DECISION DELEGATED TO HEAD OF PLANNING

Application No: H16-0836-24 **Applicant:** Miss V Frohock
Proposal: Change of use of agricultural buildings to 5 dwellings
Location: Adjacent To The Hollies Pilmore Lane Fulney
Terminal Date: 29th November 2024

Drawing
Proposed Floor Plan Unit 1 and 2

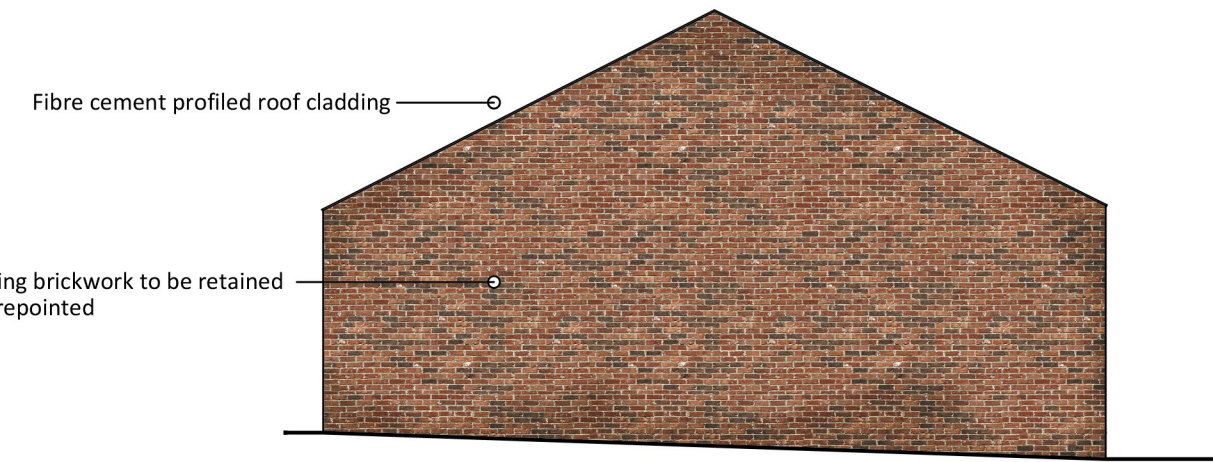
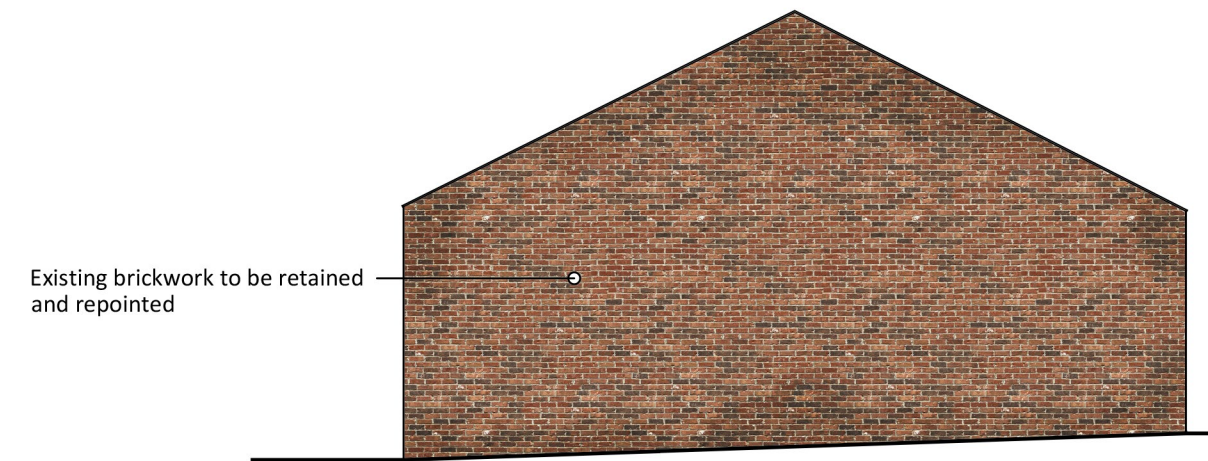
During the determination of the application, it was noted that the rear extension was too tall to be allowed using Class Q permitted development right. As such the height of the proposed extension was reduced to accord with the relevant legislation. Similarly, the roof terraces for dwellings 1 and 2 (Building 1) were combined into one terrace as it is considered that only one extension is permitted per building.

The other two buildings are proposed to feature raised terraces on the rear of the buildings. Initially, two terraces were proposed on the rear of building 1 (dwellings 1 and 2). This has been amended during the determination of the application to combine the terrace as only one extension is allowed per building. The terraces are considered to comprise permitted development and would not exceed the above referenced allowances.

Drawing
Proposed Floor Plans Unit 5

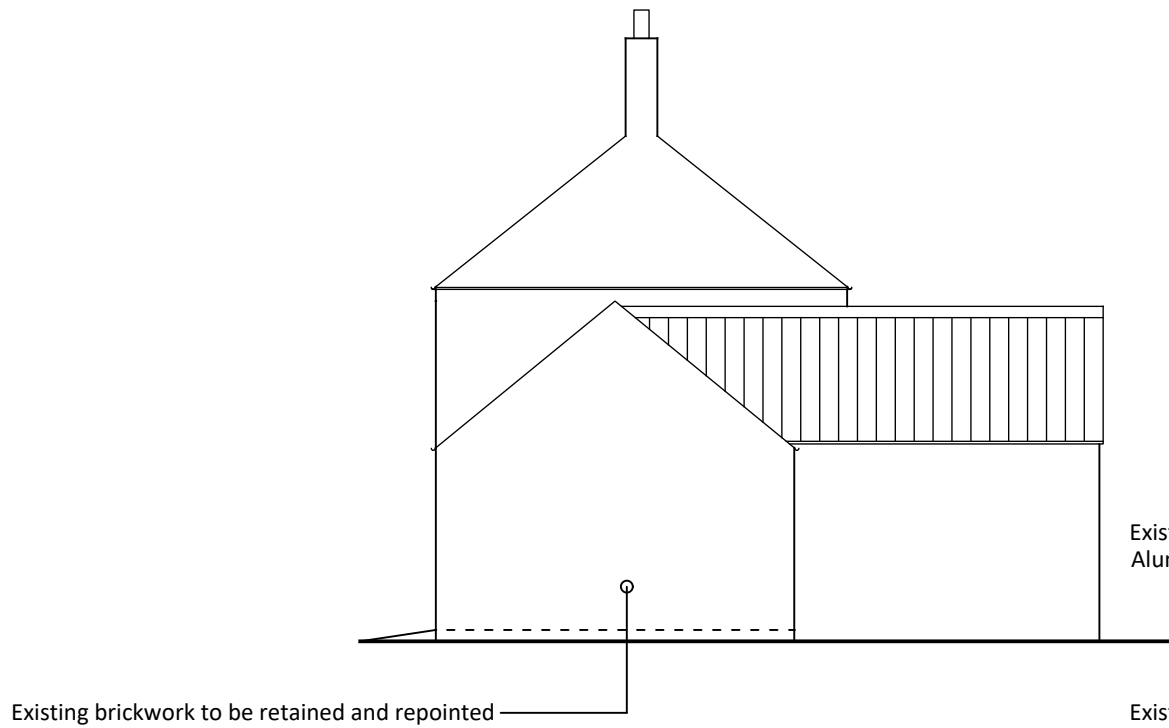
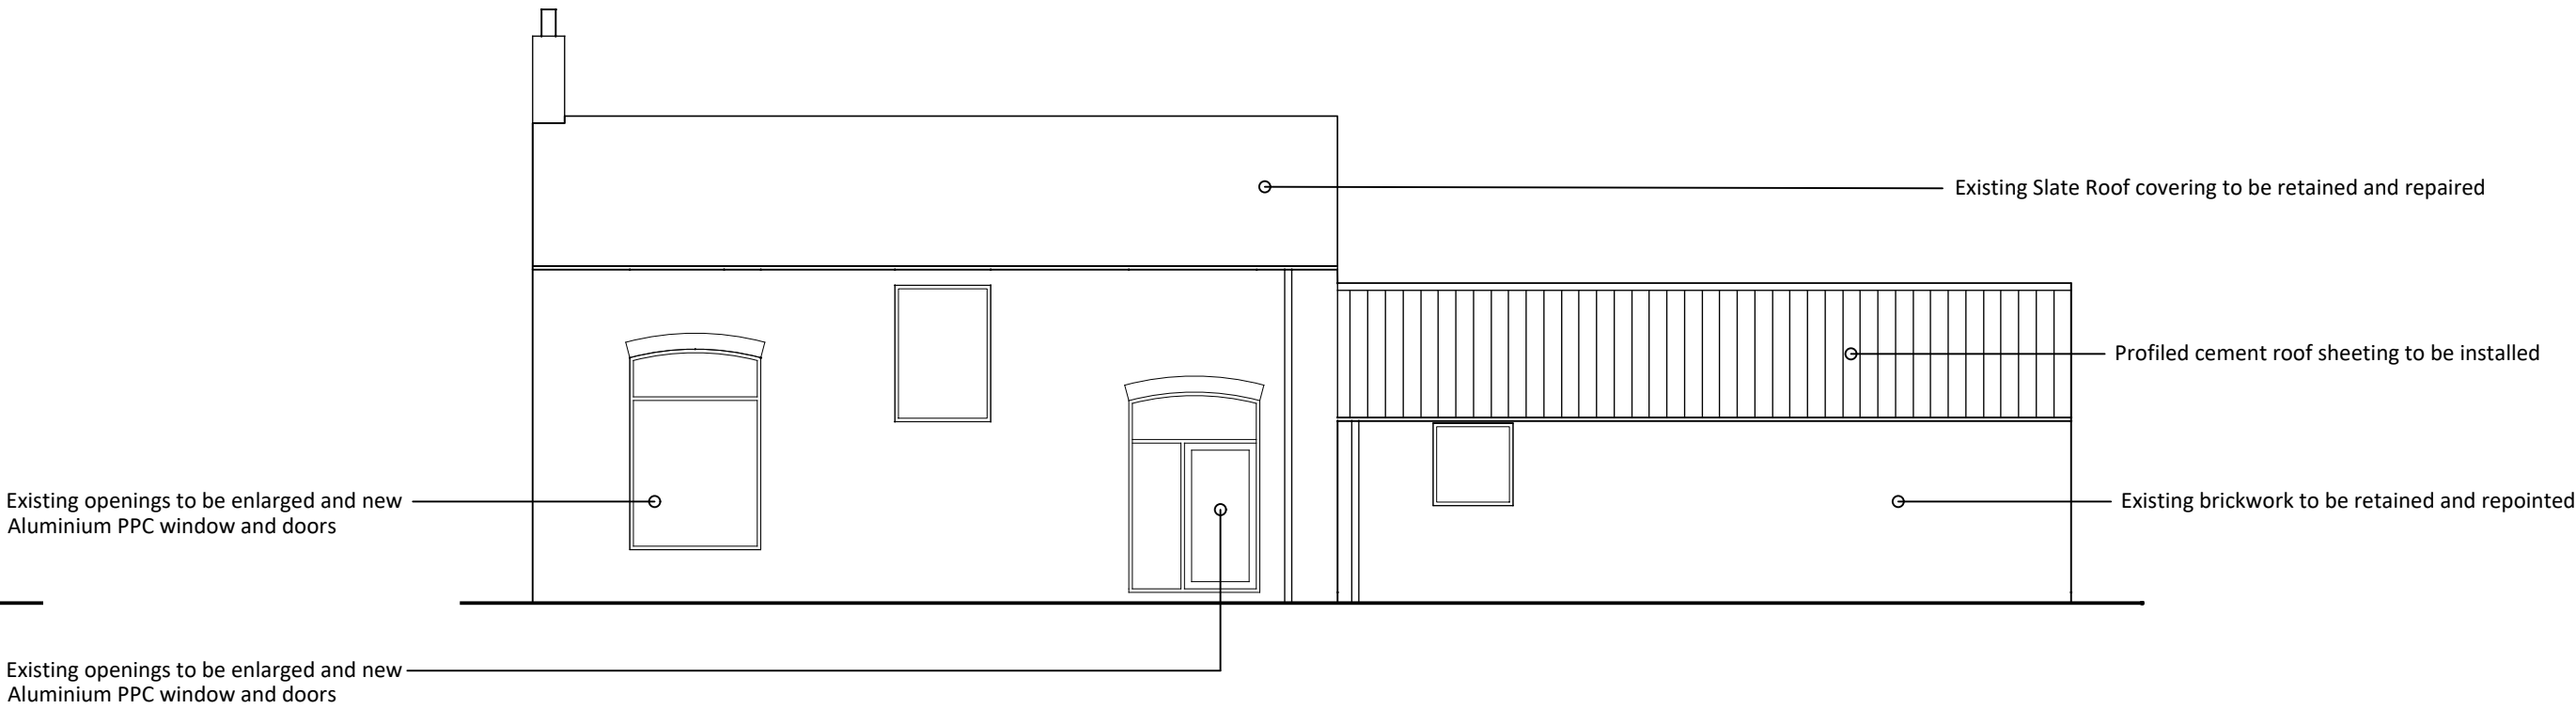
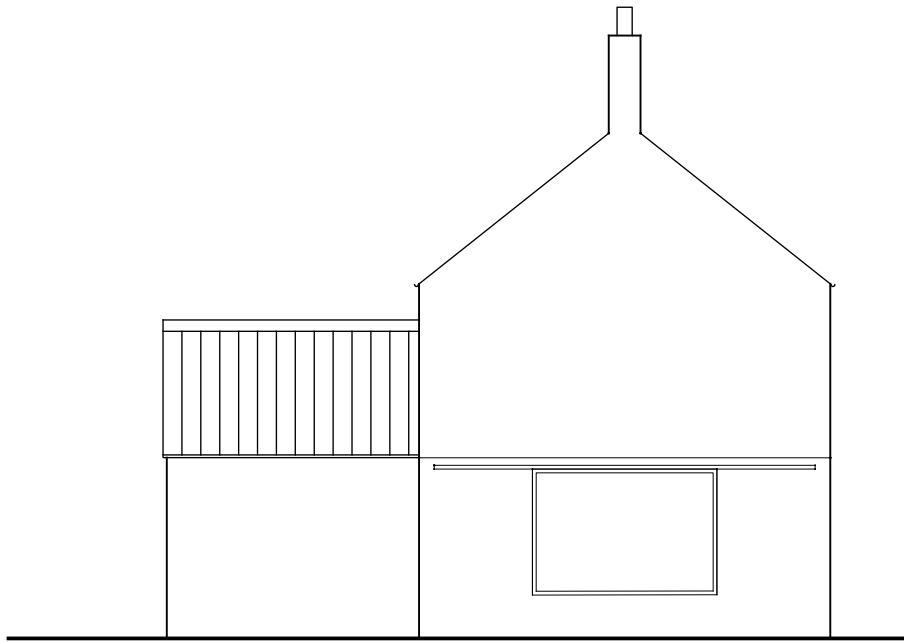
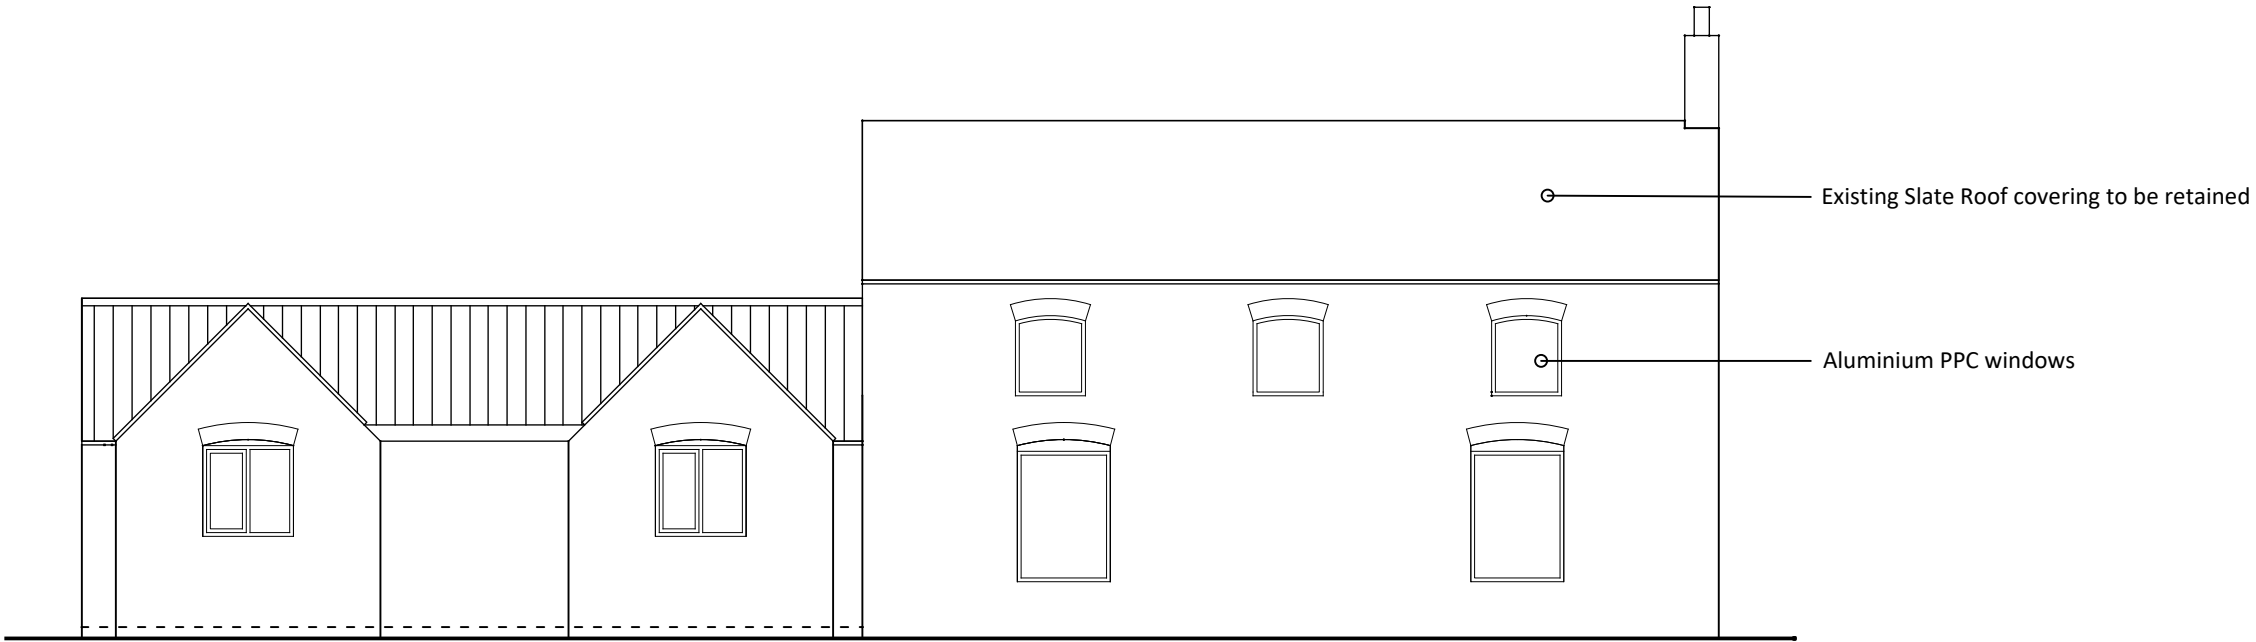
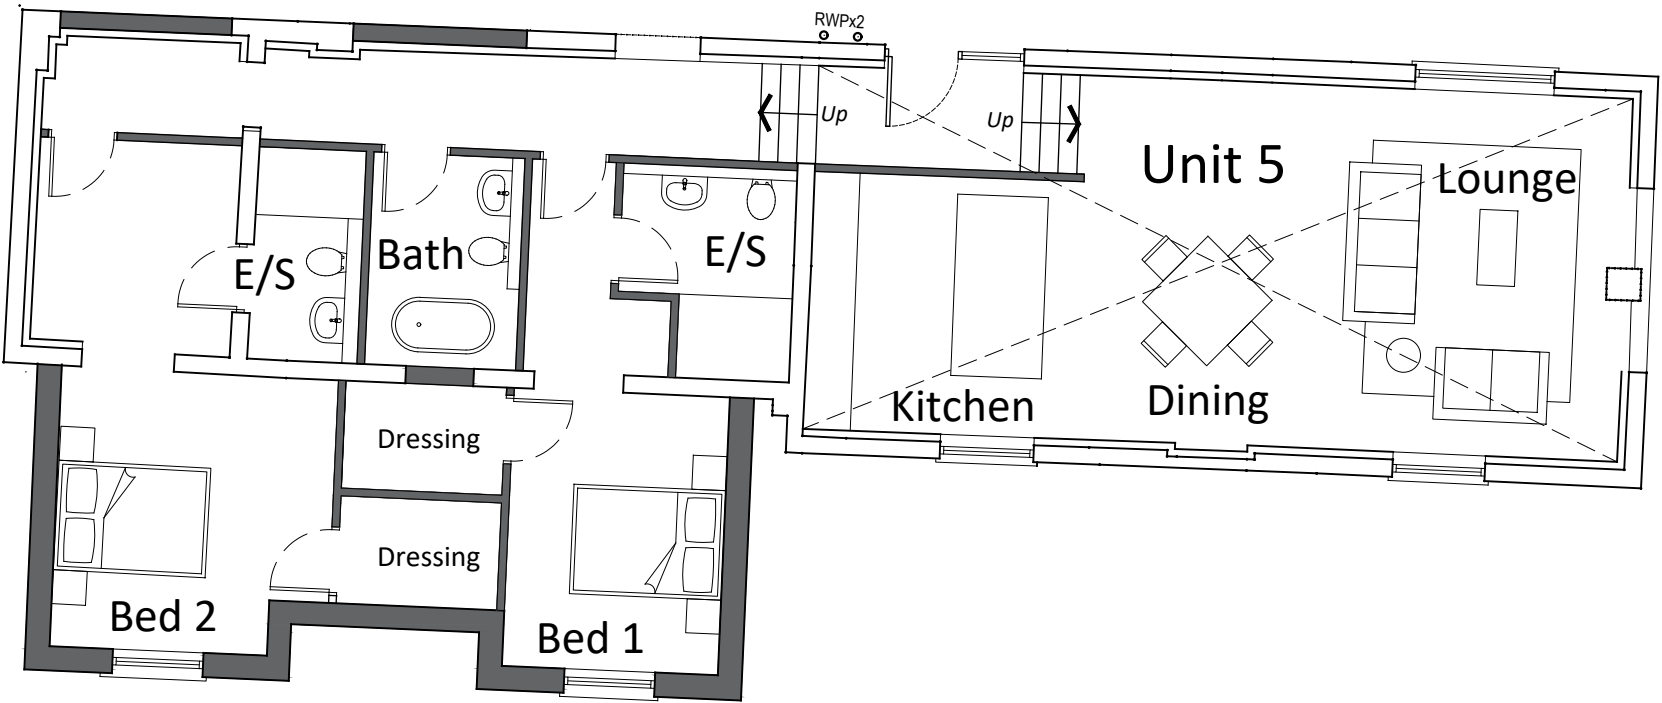
- The proposed development seeks to install a single storey rear extension on building 3 (dwelling 5). As set out previously, the proposal has been amended as initially the height of the extension ridgeline was 4.4m, thereby exceeding the maximum height allowance of 4m. The extension has therefore been amended and now the ridgeline measures 4m from the ground level. The proposed extension therefore accords with the above referenced allowances. For example, it would not extend from the building by more than 4m and is located on the rear of the building.
